**Your Ref:** OWPC24478  
**Our Ref:** FG/100/19/HH 31-08-2019  
**Please ask for:**  
Zac Denton

Single storey front extension  
23 West Drive Ferring

*Planning Reference number FG/100/19/HH  
23 WEST DRIVE, FERRING, BN12 5QZ  
CASE OFFICER MR Z. DENTON*

Proposed Floor Plan

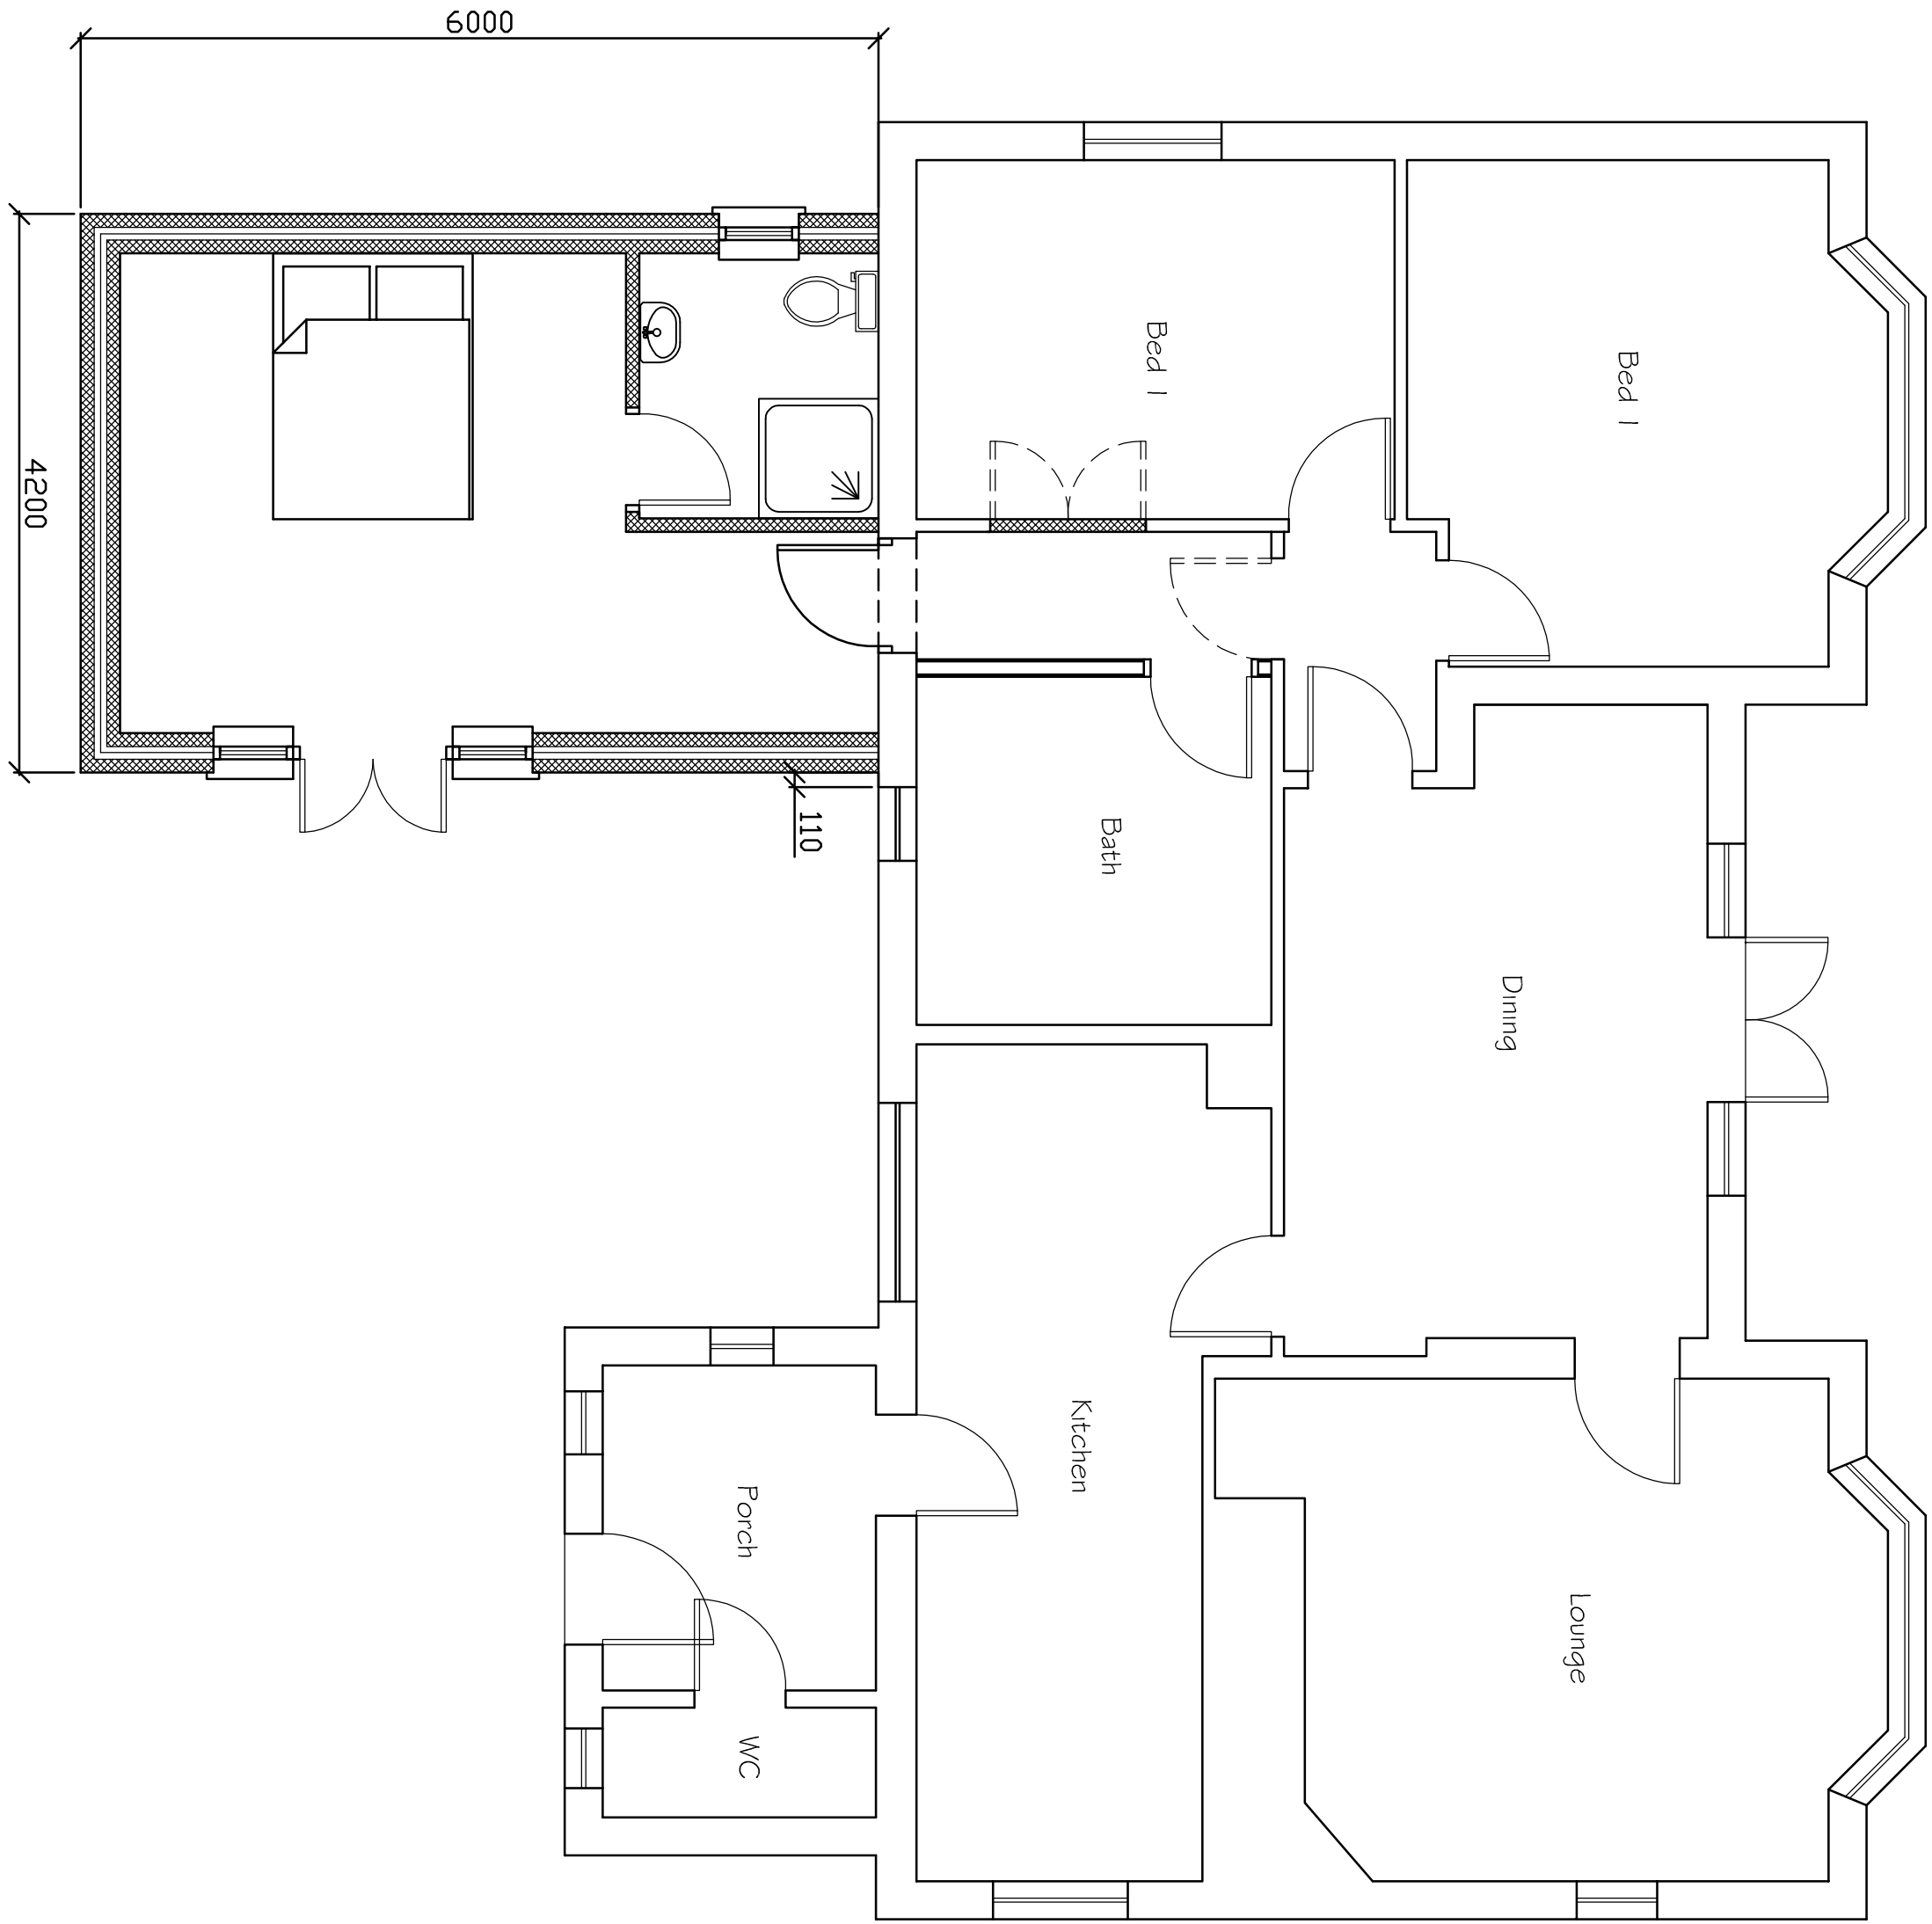
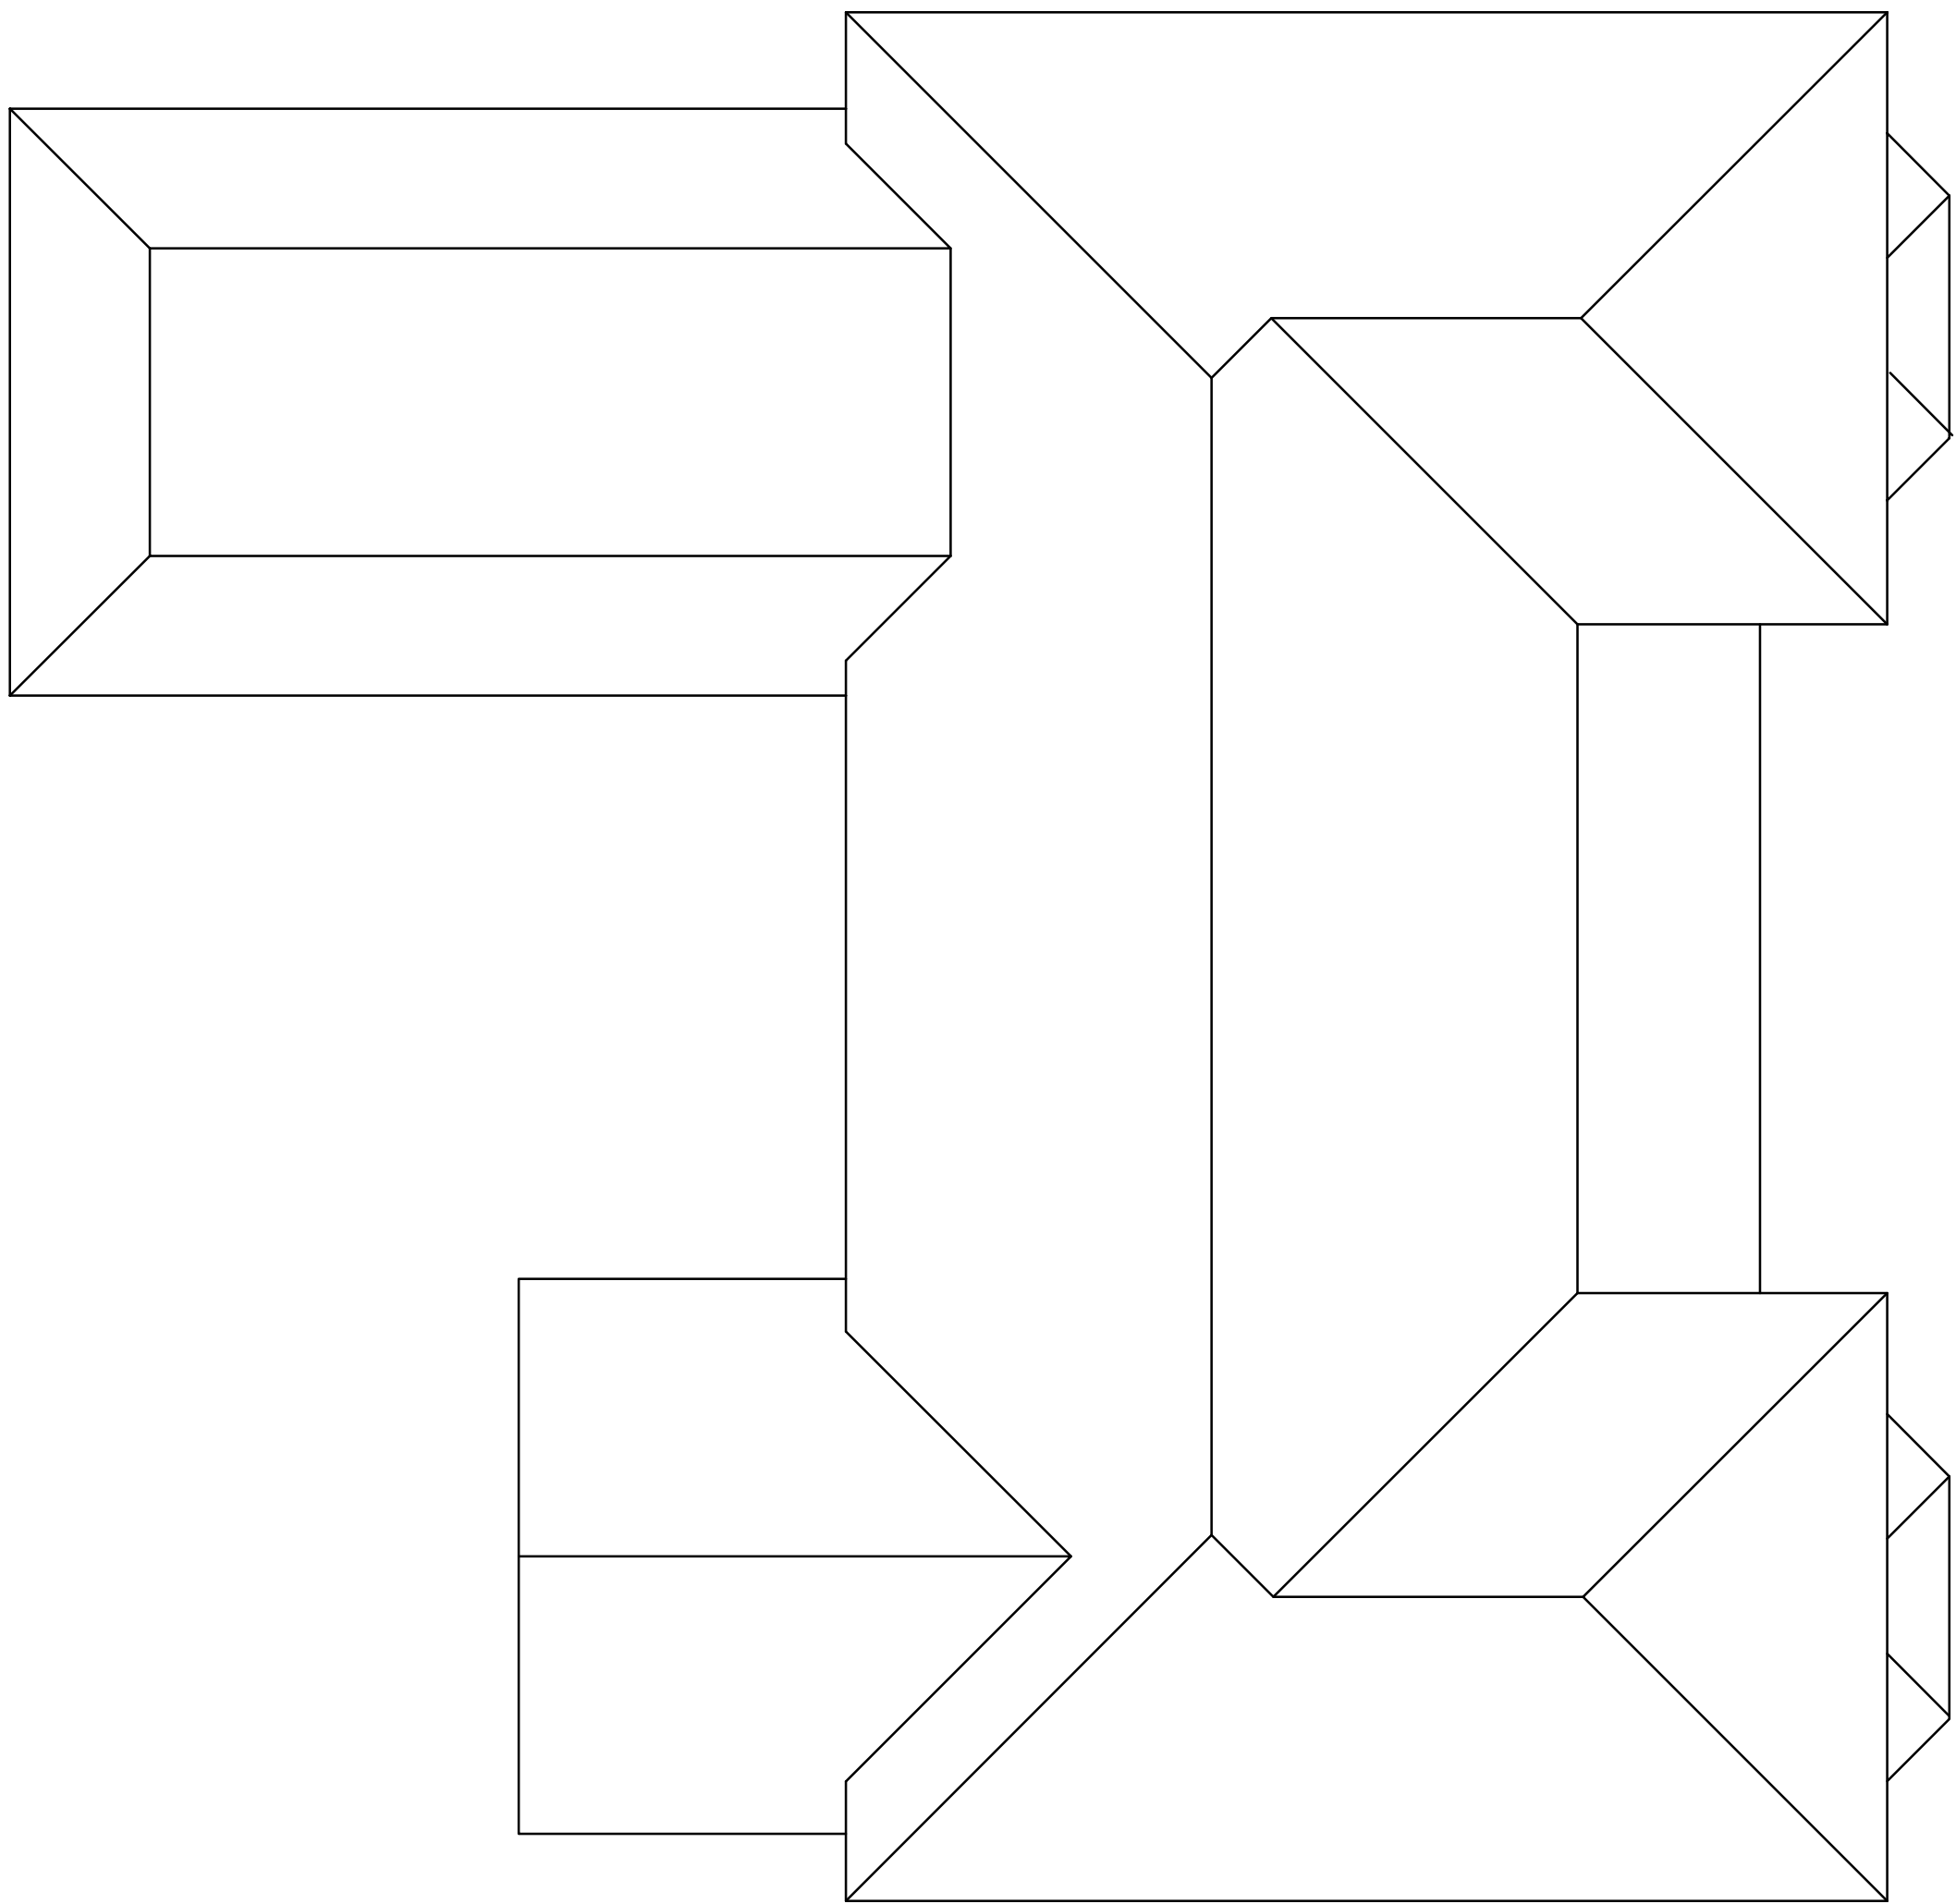
*The proposed extension would impact greatly on the amount of natural daylight and sunlight entering my property. This building would overshadow my property and obscure essential light. This proposed extension runs parallel to the back of my house, my living room just 2180mm from the boundary fence. This extension would be built approx 1400mm from the boundary and just 3580mm from my patio doors. This I feel is unacceptable.*

*The proposed extension is to build a bedroom with ensuite facilities. The opening window to the ensuite is positioned directly opposite my patio doors, the patio doors lead into my main living area. Below this window is a toilet which is 1400mm from the boundary wall and close to an area I like to sit and enjoy my garden. My objection is to the loss of privacy, overlooking and the noise from daily ablutions and the use of the toilet, which would most definitely be heard from my property.*

*I object to the design, layout, and density of the proposed building in respect of its size, width, height, massing and also the overpowering and overbearing affect on my property. The impact of one continuous wall along the back of my very small garden would diminish greatly my rights to enjoy my garden and property. The scale and massing of this proposed extension is out of proportion to the large amount of external land available at 23 West Drive.*

*This extension would adversely affect the visual amenity that is enjoyed at my property. The overbearing nature of this proposed extension would overshadow my small strip of garden. It would create a continuous wall that would obliterate light and create a feeling of being hemmed in. The close proximity of the bathroom is unacceptable when the 'use of the facilities' would be audible from my property. The design of this proposed building is unusually to the front of the house, which is somewhat irregular when considering the vast area of land available. I believe an alternative site at the back of the property would be more in-keeping with this property.*
